From: [Justin Turnbull](#)
To: [Chris Cruse](#); [Jeremiah Cromie](#)
Cc: [Arden Thomas](#); [John Schultz](#); [Dan Carlson](#)
Subject: Re: BL-22-00020 Schultz - Request for Updated Survey/Clarification
Date: Saturday, November 19, 2022 12:47:15 AM

From: Jeremiah Cromie <jeremiah.cromie@co.kittitas.wa.us>
Sent: Thursday, October 27, 2022 8:11 AM
To: Chris Cruse <chris@cruseandassoc.com>; Jason Rinehart <jason@cruseandassoc.com>; 'john57schultz@gmail.com' <john57schultz@gmail.com>
Cc: Justin Turnbull <justin.turnbull@co.kittitas.wa.us>
Subject: BL-22-00020 Schultz - Request for Updated Survey/Clarification

Please see the attached survey comments from the final preliminary survey for Boundary Line Adjustment application BL-22-00020 Schultz. Can you please provide clarification on items 1, 4-6 in the survey comments memo or provide an updated preliminary final survey? I have also included what was sent for the final preliminary survey and lot sums for this BLA.

Drawing file: BL-22-00020 Schultz / BL-22-00002 Schultz redline 11-18-22.pdf

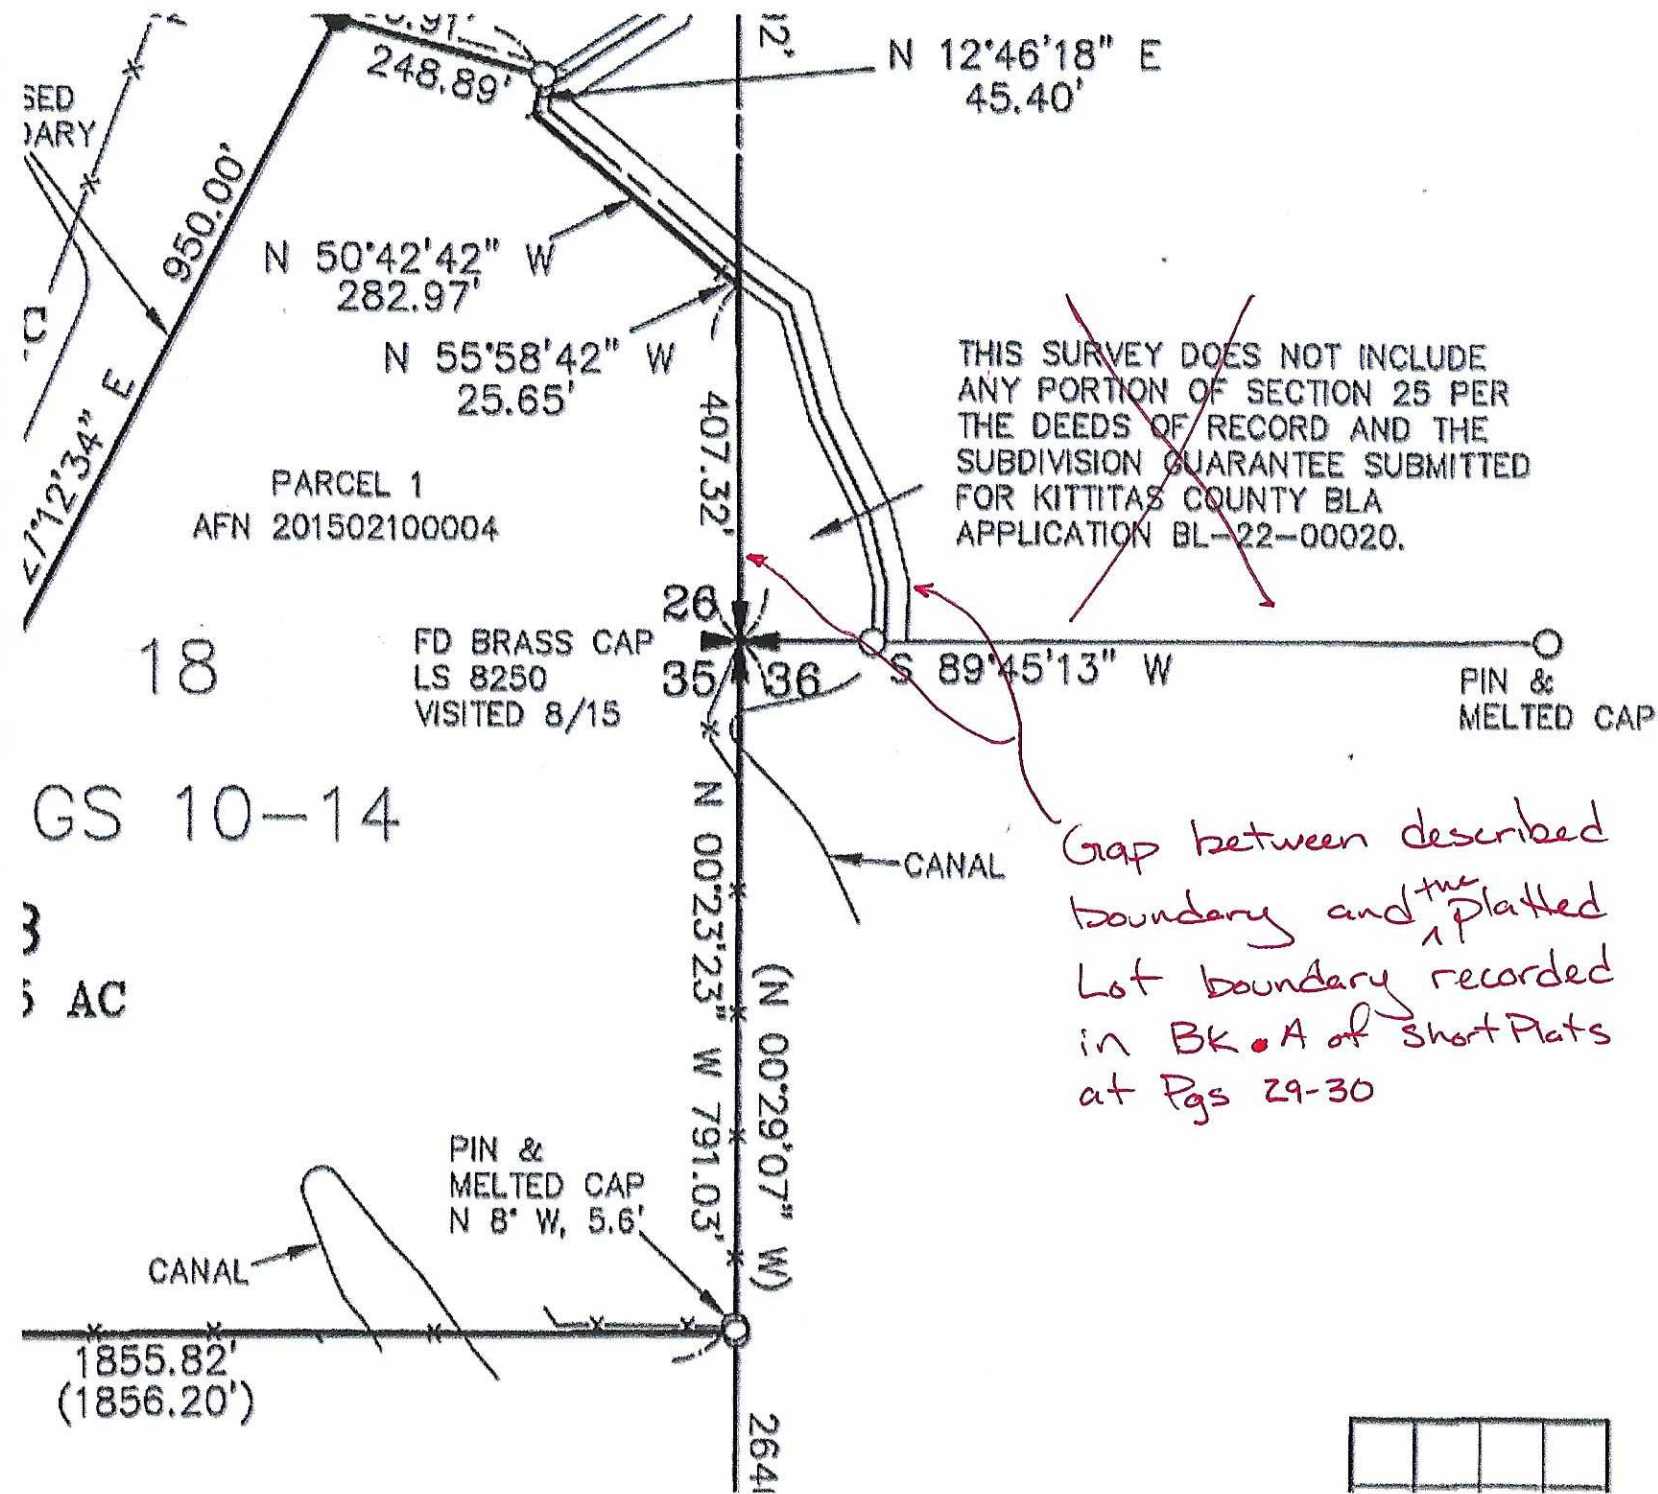
Justin – Assessor is working on updating the tax map to match the section line but may take a week. Attached is a quick exhibit that will hopefully get this survey recorded. I do not agree with “gap in ownership” as someone owns the property. I do agree with gap between the described boundary of this property and the platted boundary to the east. Does the redlined note address your concerns and we can proceed with recording?

Chris and Jeremiah,
The proposed note by Mr. Cruse addresses my concerns.

SCHULTZ PROPERTY

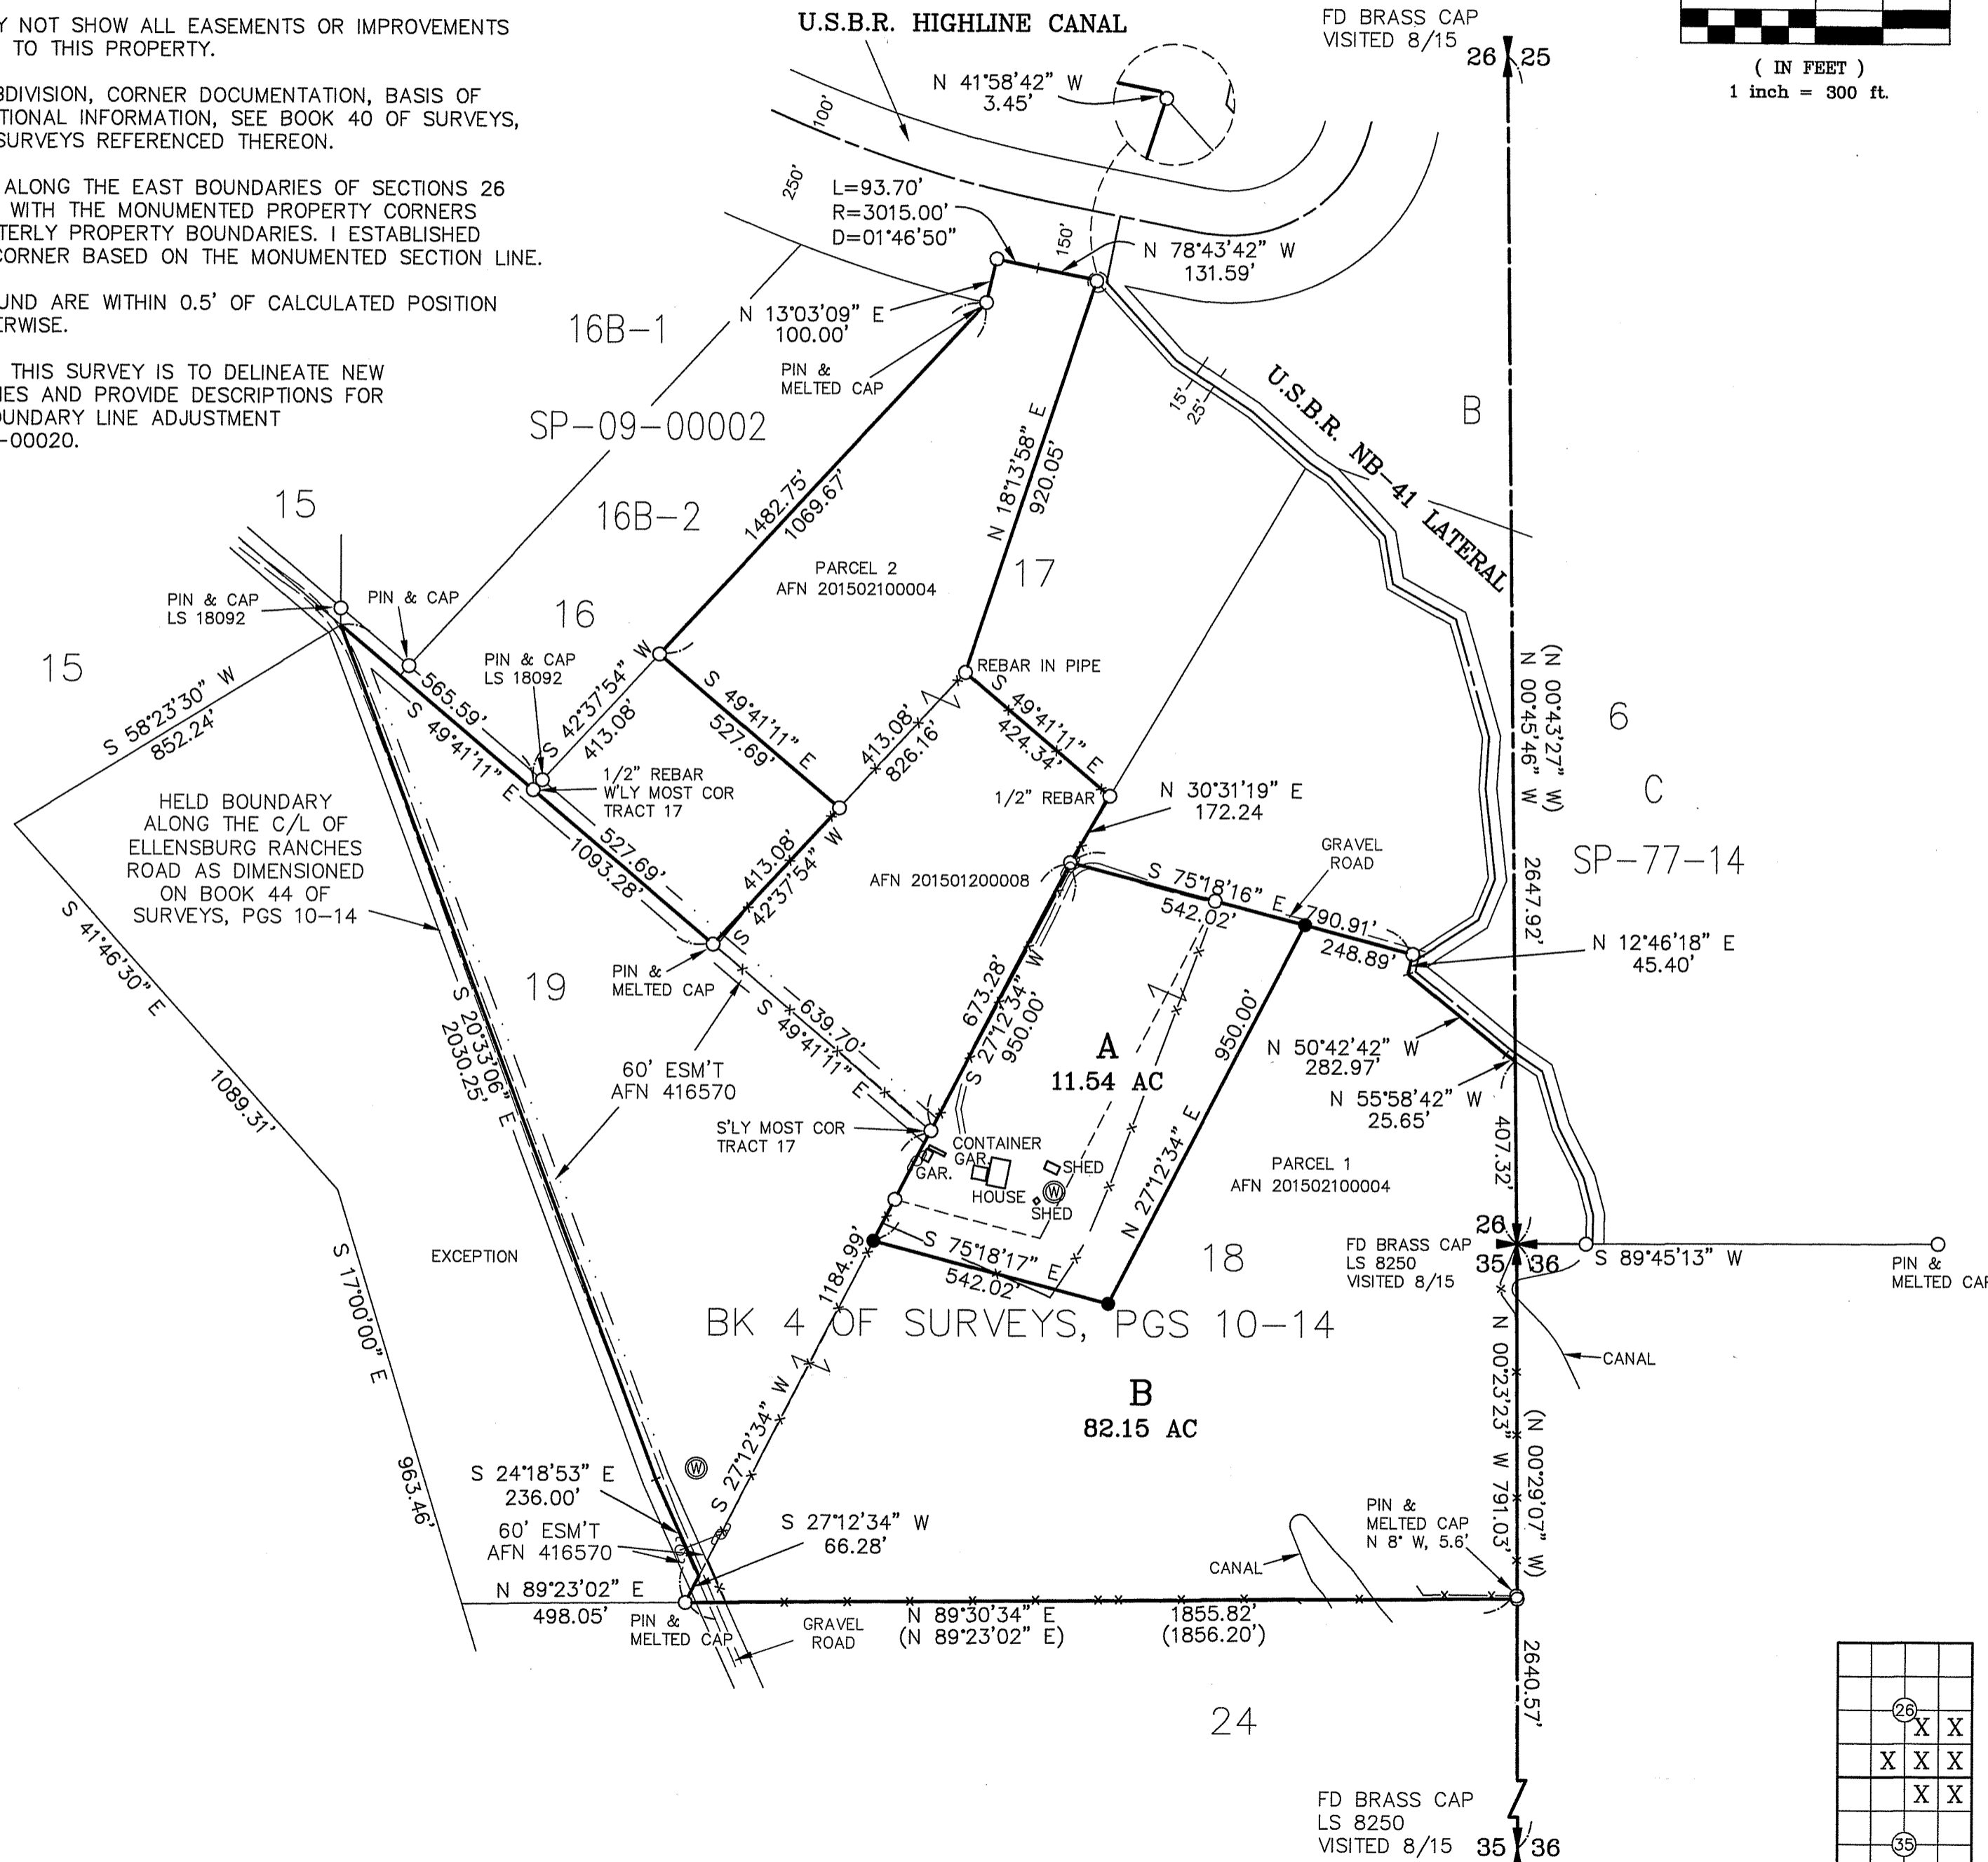
I interpret this as (at a minimum) the potential discrepancy must be identified and shown on the face of the map. I would propose that the note added by Mr. Cruse has not completed this requirement. Adding language such as "Potential ownership gap", "This portion identified in prior surveys as part of Parcel X" or any similar such language would meet the State's survey map requirements.

As for the ownership piece in your questions, it is required under RCW 58.17.255 and WAC 332-130-050 (1)(B)(f)(vi) and WAC 332-130-050(1)(B)(f)(vii). Your previous survey that was included in the application submittal included this triangle piece. Any ambiguities, trespasses or hiatuses (gaps in ownership) need to be noted on the face of the survey (not necessarily corrected).

The portion falling in Section 25 is shown both on the Compass GIS map as well as a prior survey by you (SUR: 40-30), as well as being excluded by prior adjacent survey (SP:A-29). The concern is that unless you or the title company can place the portion correctly to another parcel number, it MAY cloud the title and be perceived as an illegal division of land.

Understandably this MAY be more involved than what you (or your client) are prepared to do. If this is the case, please just note the possible gap in ownership on the face of your survey.

Item 4 about delineating bodies of water has come up on several applications now and unsure what is requiring or triggering this. In this case the pond is seasonal and only has water after snowmelt but is there code requiring the ponds or waterways on final surveys?

Item 6, as per the submitted title report this ownership does not extend into Section 25. I do not know of any gaps in ownership and appears to simply be a mapping issue on COMPAS. The assessor's summary describes this ownership as not owning anything in section 25. When this BLA is sent to the Assessor I am sure the mapping will be corrected to match this survey and not planning to address for this survey.

There is no ownership gap or ambiguity. Gordon the landowner to the east stated he owns the property within section 25 which exactly matches this survey and title report. The COMPAS map is not correct and can ask the Assessor about it.
